An
Bord
Pleanála

Board Direction
BD-016486-24
ABP-317121-23

SWORDS TO CITY CENTRE SCHEME FRANK FLOOD BRIDGE COVER SHEET

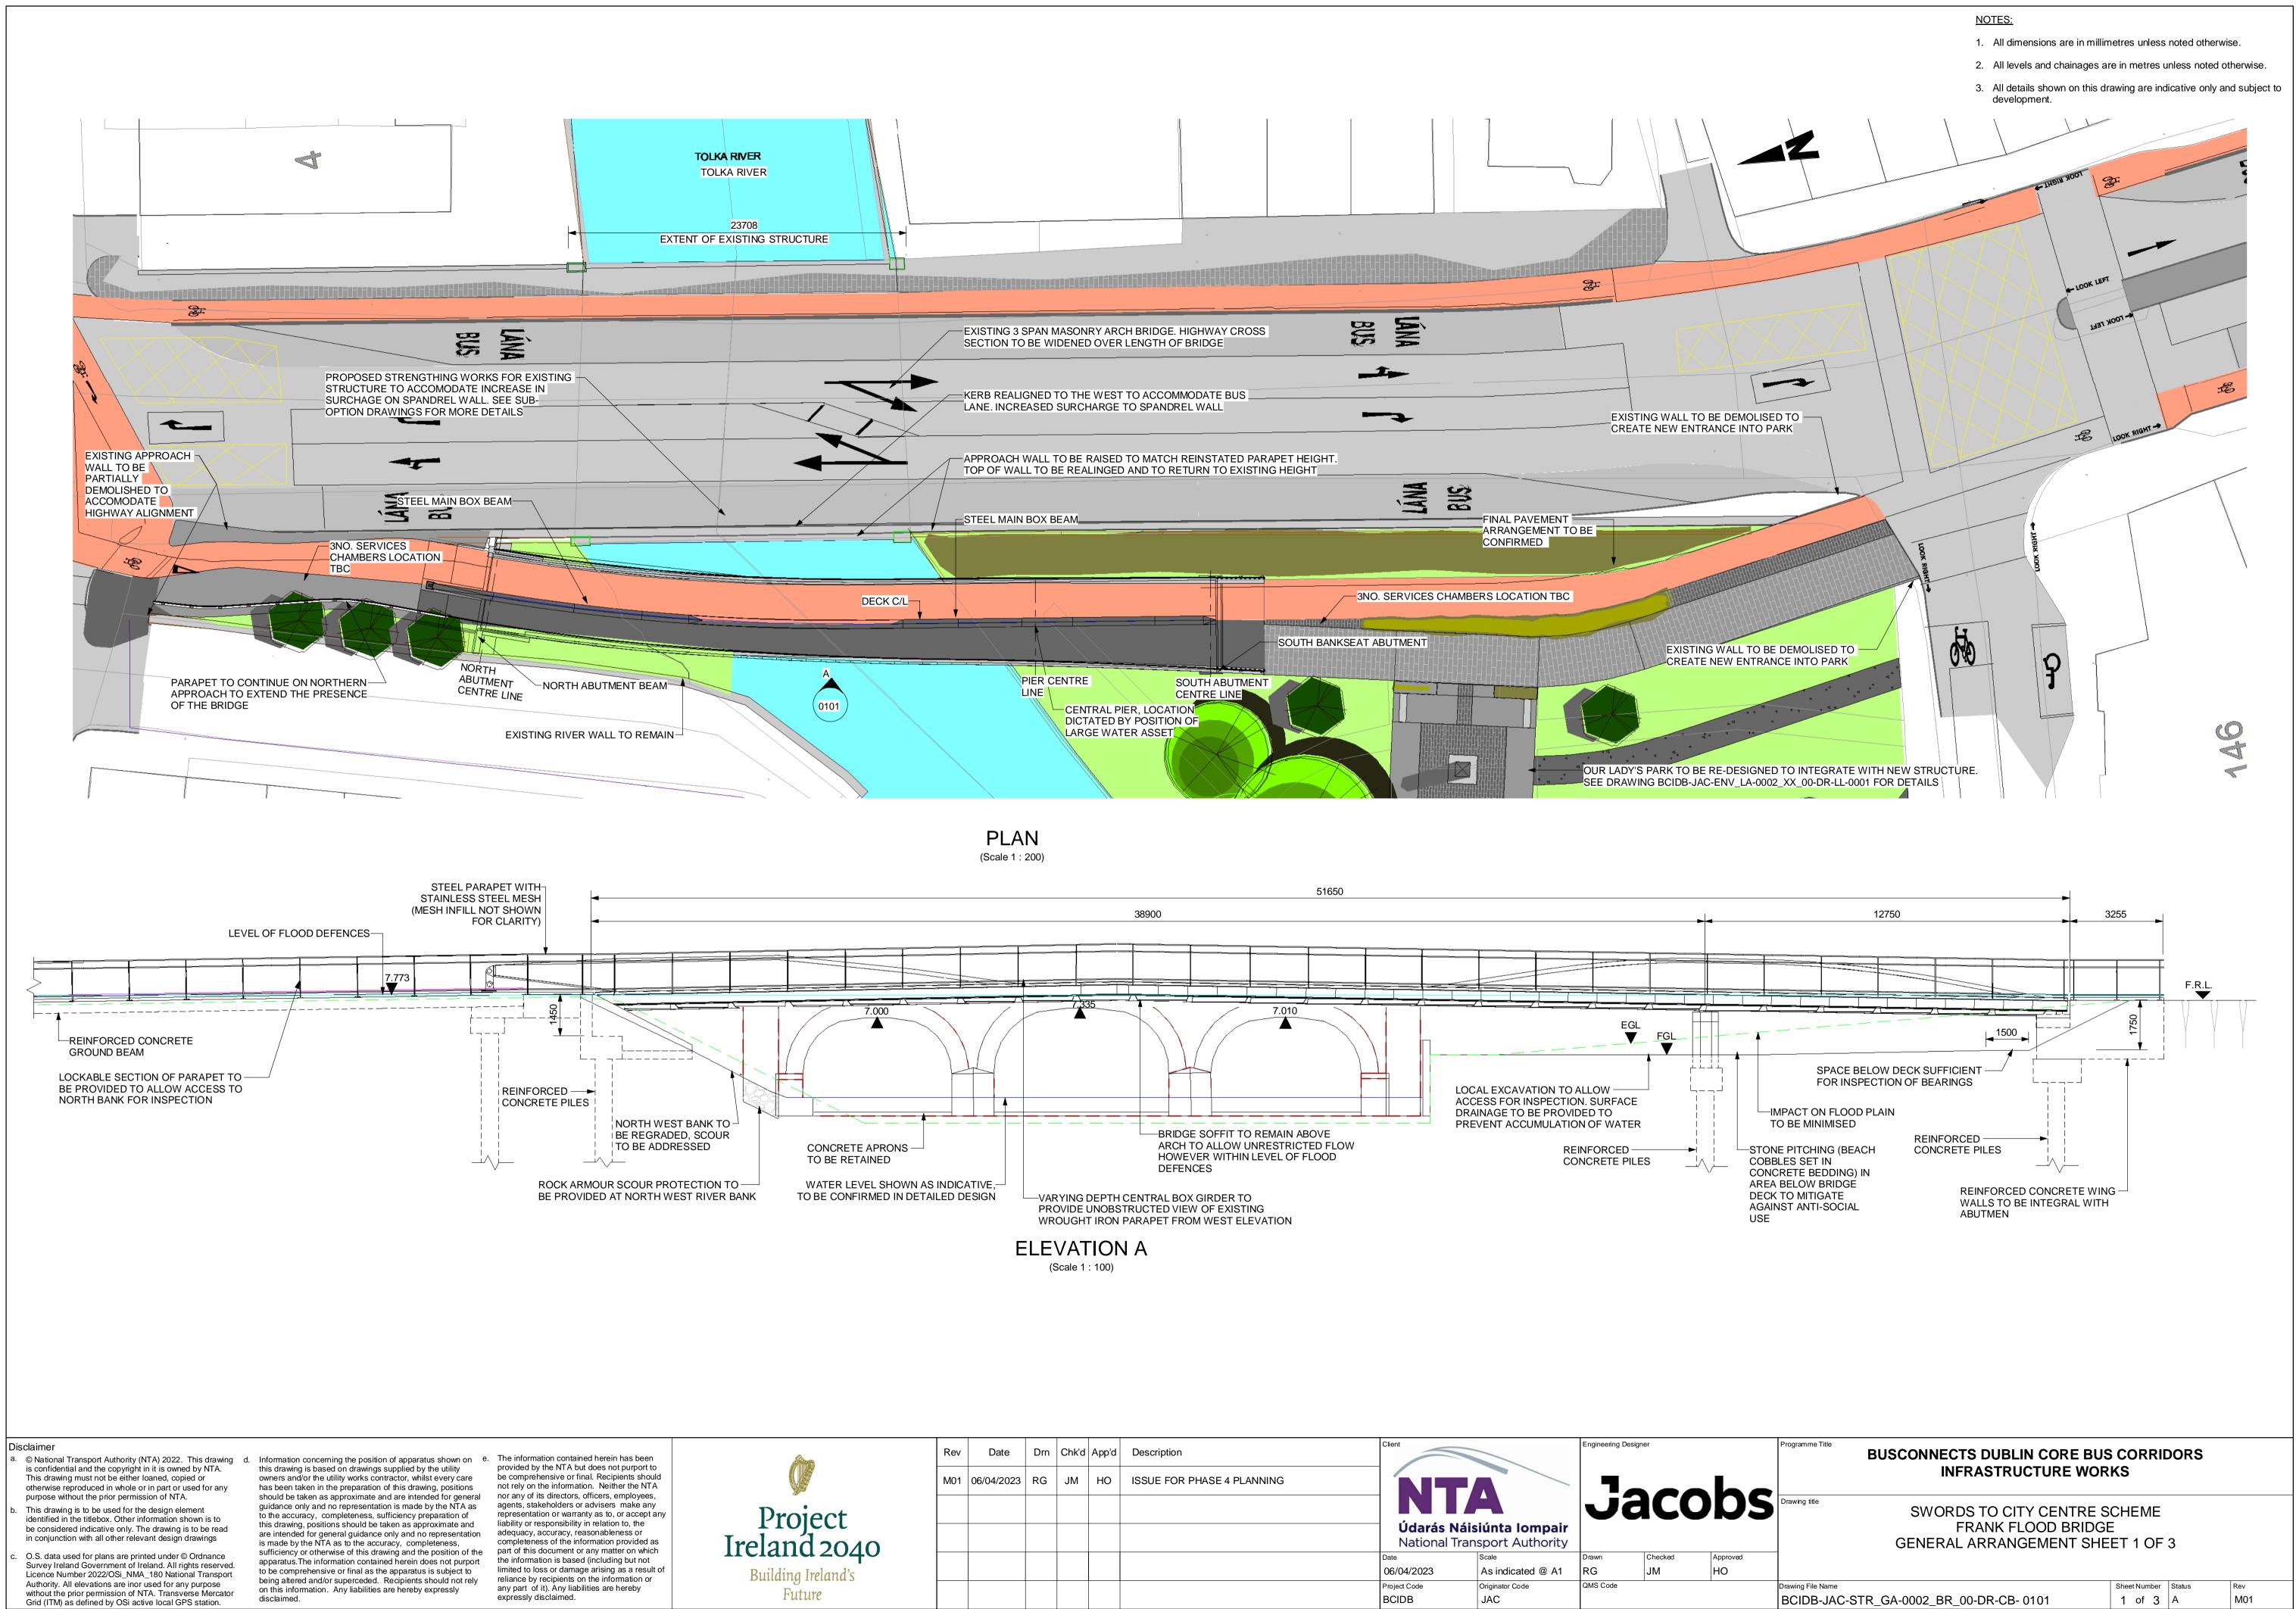
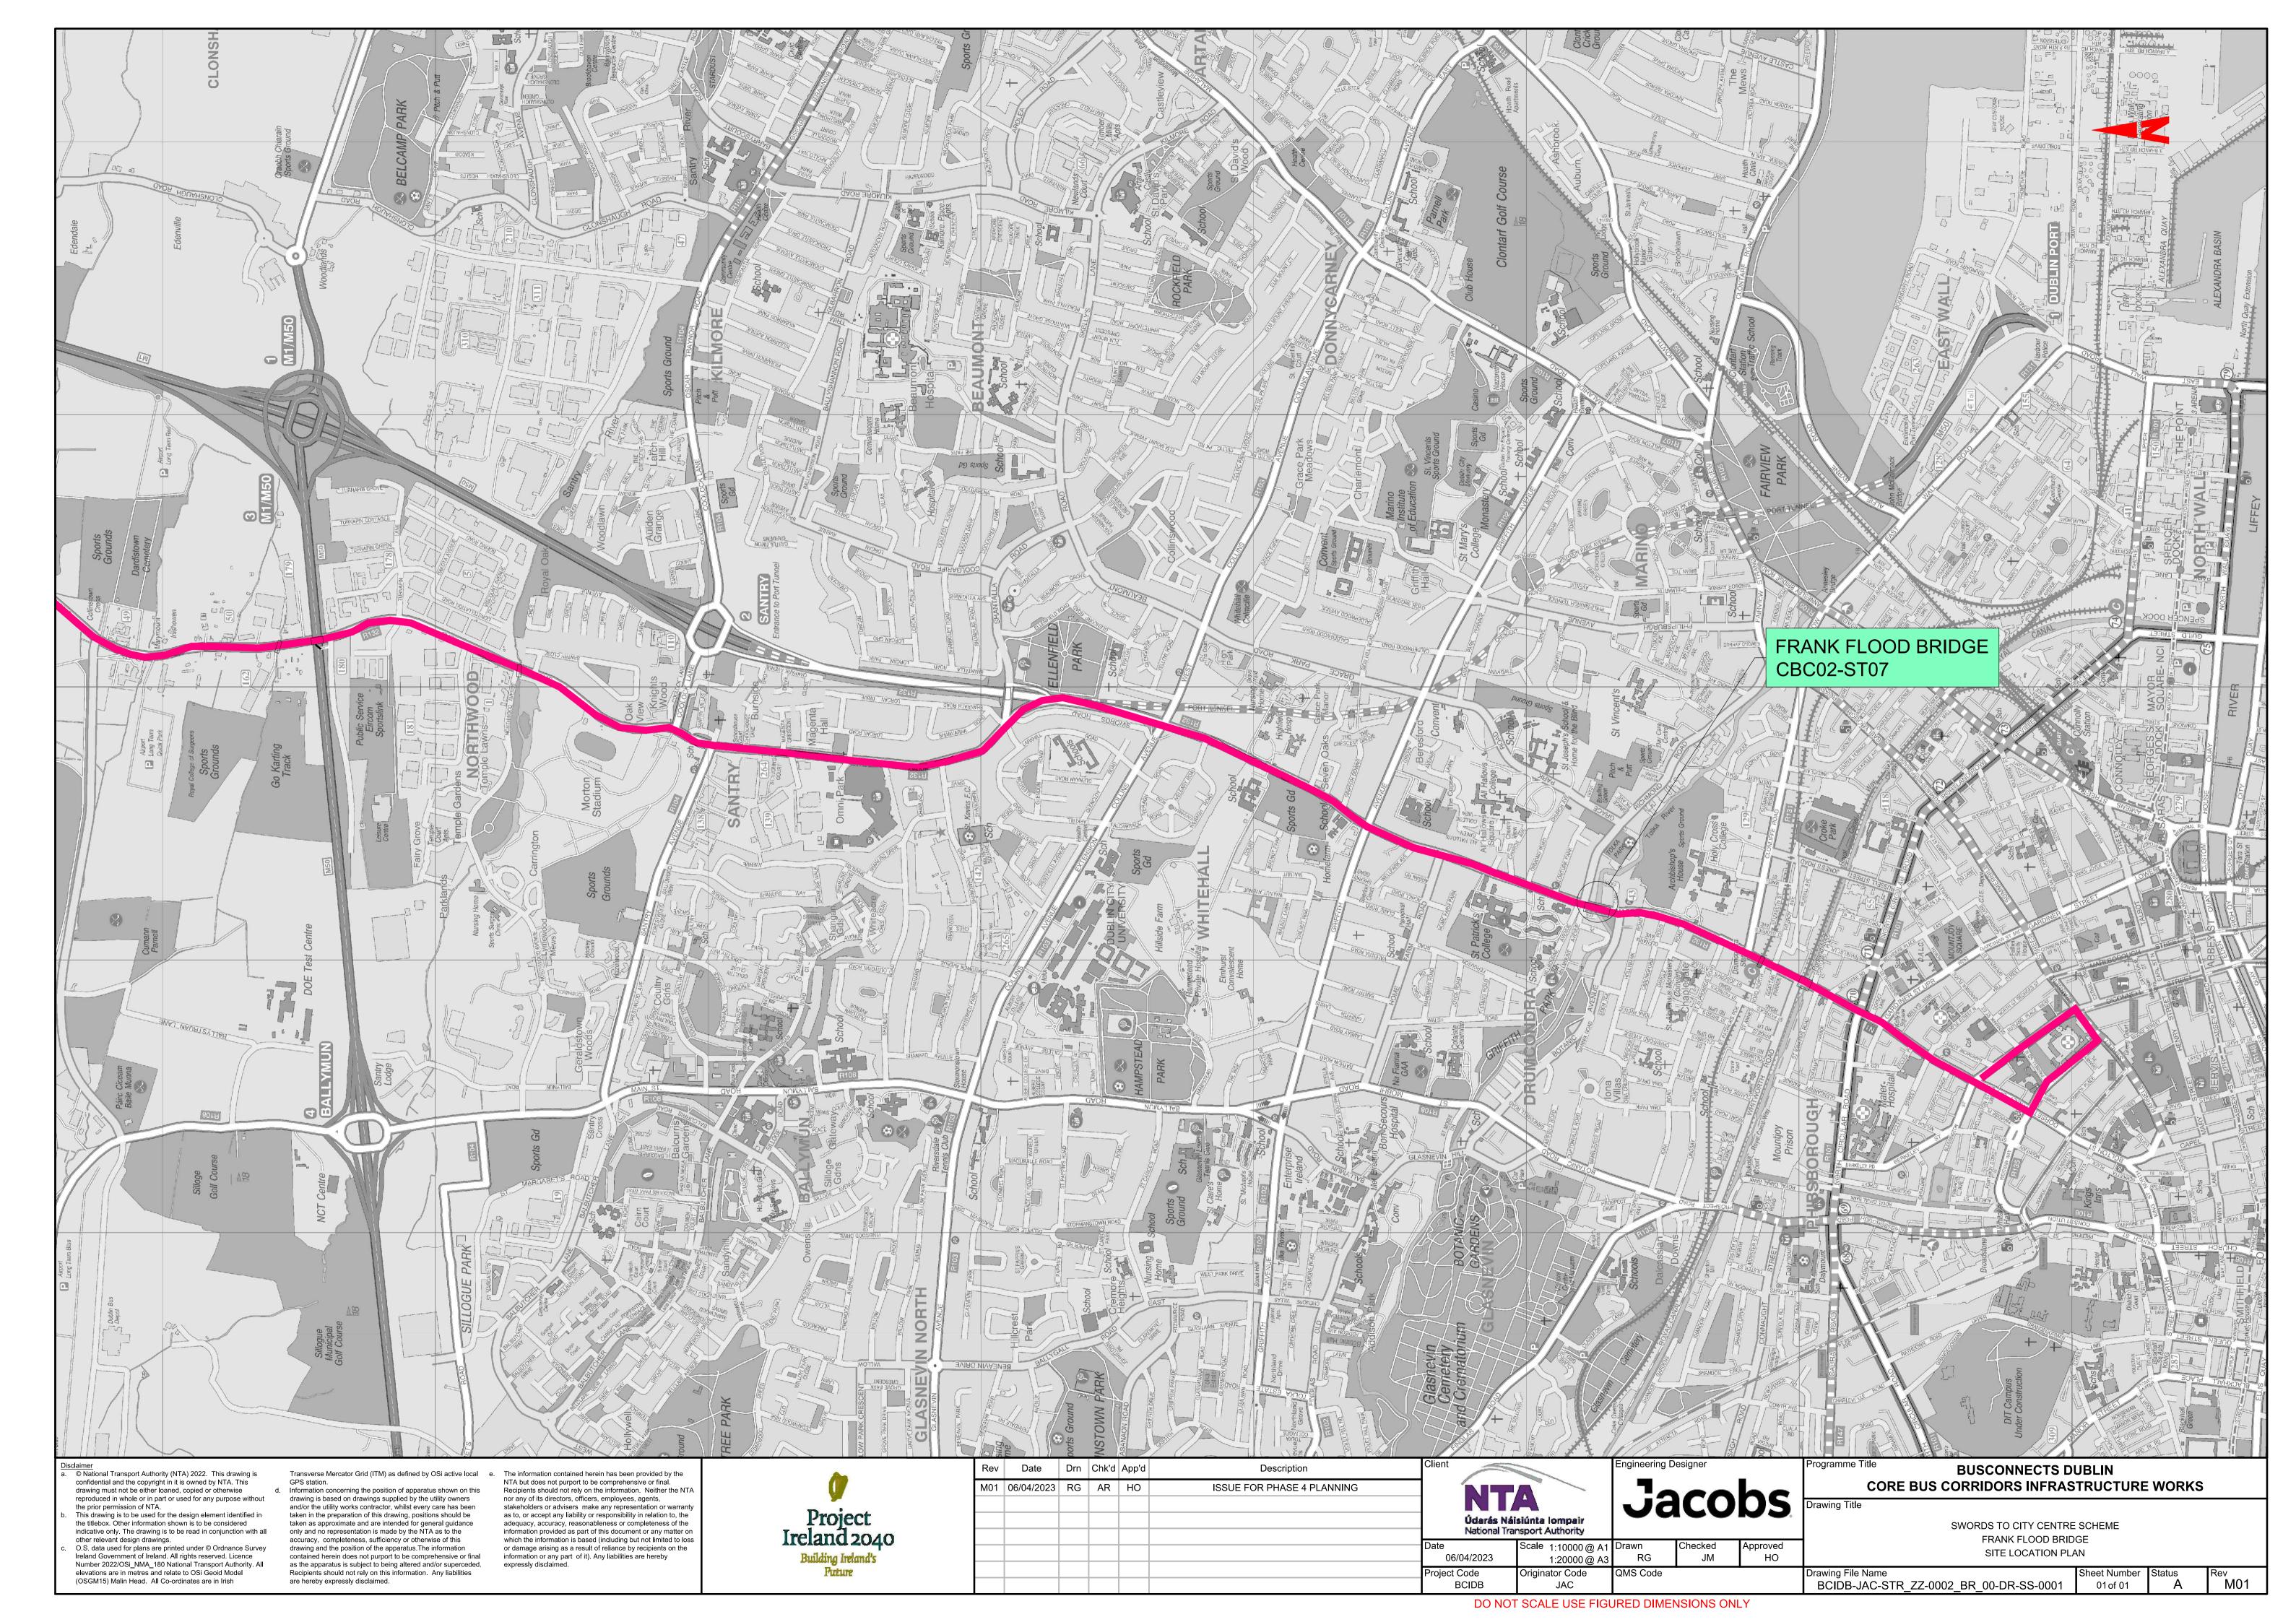
6. Prior to commencement of development, the developer shall agree in writing with Dublin City Council the details of the type of finishes/materials for the proposed pedestrian/cycle bridge adjacent to Frank Flood Bridge.
